**Application by National Highways for an Order granting Development Consent for
The Lower Thames Crossing**

**WRITTEN REPRESENTATION ON BEHALF OF
ST. MODWEN DEVELOPMENTS LIMITED
(PLANNING INSPECTORATE REFERENCE:
20035817)**

A. Works Plans Composite - Sheet 45 (M25 junction 29 and surrounding land)
 (Work Numbers: 9D, 9E, 9F, 9G, 9I, 9J, 9K, 9L, 9P, 9U, 9Z, MU85, MU87, MU88, MU89, MU90, MUT32)

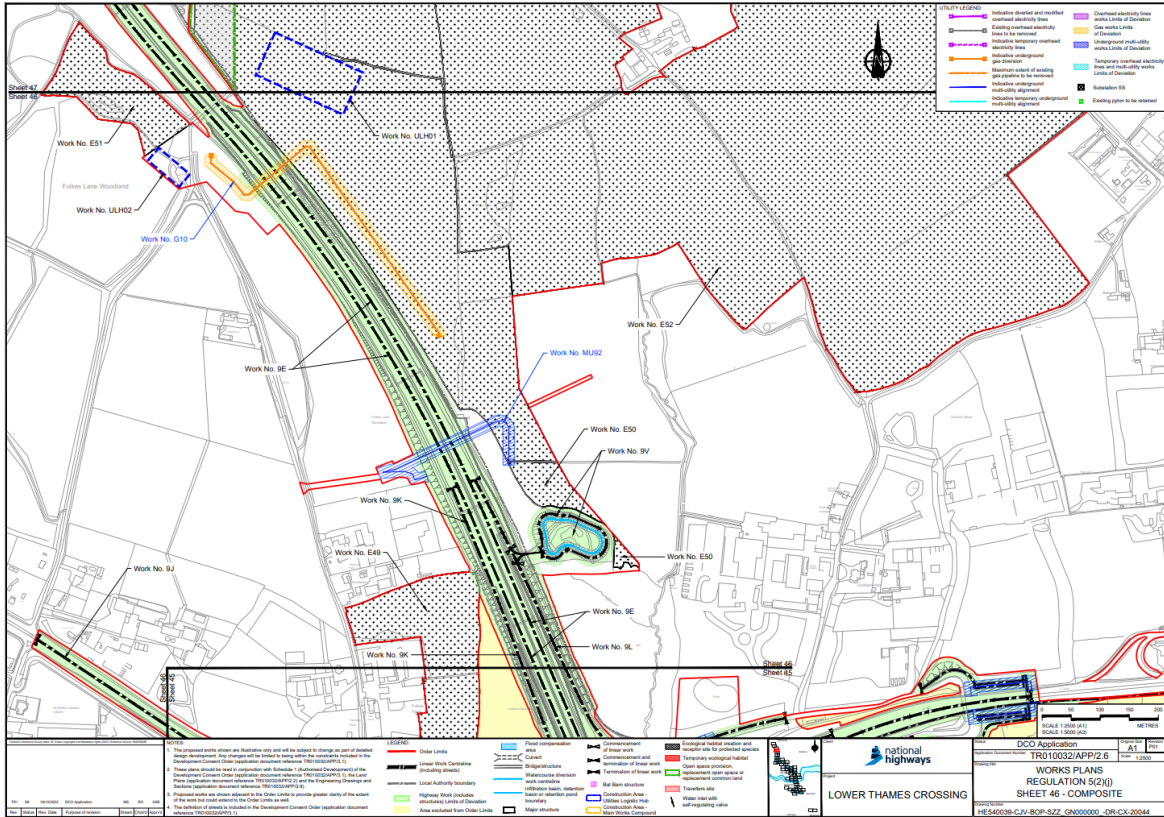
- 1.5 Whilst SMDL is broadly supportive of the LTC project as a whole, the BEP site is significantly impacted by the proposals insofar as they relate to J29 and the surrounding road network. SMDL and Padfield have therefore been engaging with the Applicant over a number of years in order to seek to minimise these impacts and identify technical solutions for how BEP and LTC can both be delivered in a timely fashion.

- 1.6 SMDL has welcomed the opportunity to engage with the Applicant and acknowledges that significant progress has been made in reducing the impact of LTC on BEP. However, there remain a number of key outstanding issues which must be resolved in order to provide SMDL with comfort that LTC will not have an unacceptable impact on BEP. These can be summarised as follows:

E. Work No. 9Z (Sheet 66) – Walking, Cycling, Horse Rider bridge over A127

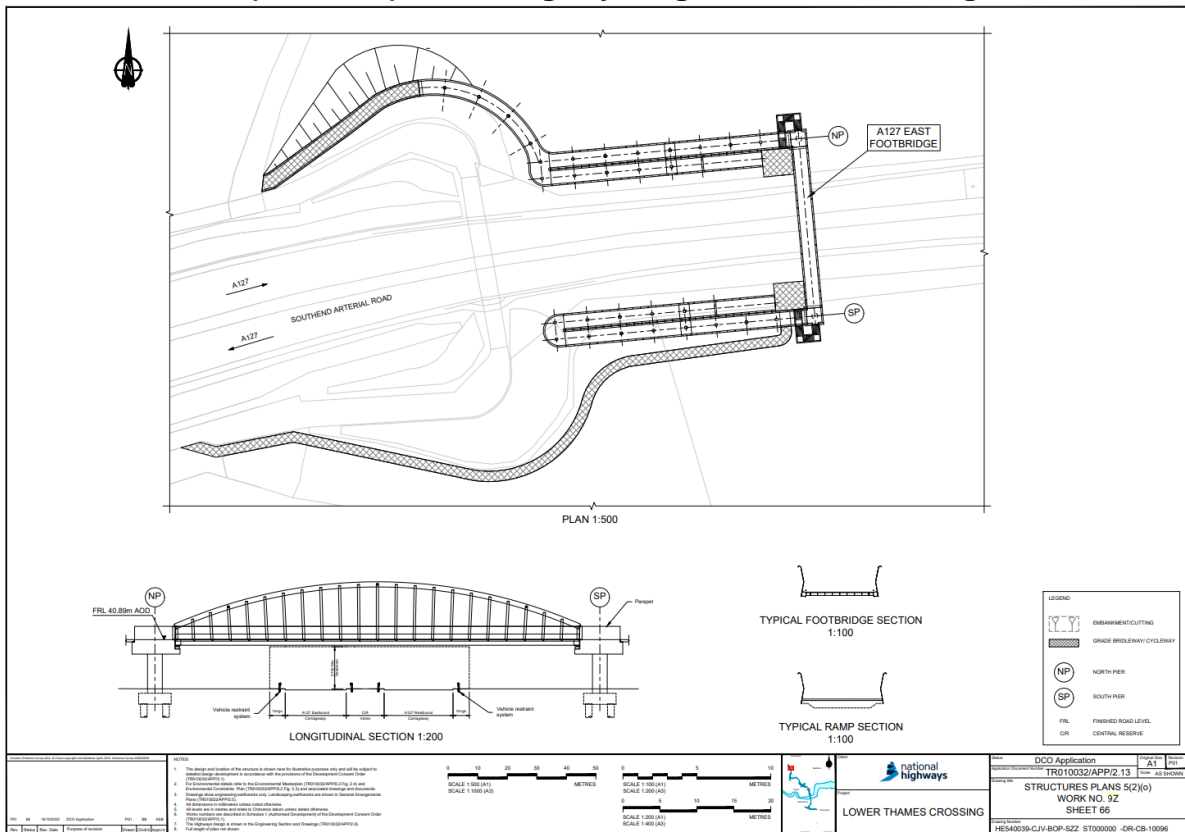
- 1.6.1 the impact of the LTC proposals on the proposed access to BEP from the B186;
 - 1.6.2 the impact on the proposed northern BEP vehicular access of the proposed LTC bridge for walkers, cyclists and horse riders (“**WCH**”) over the A127;
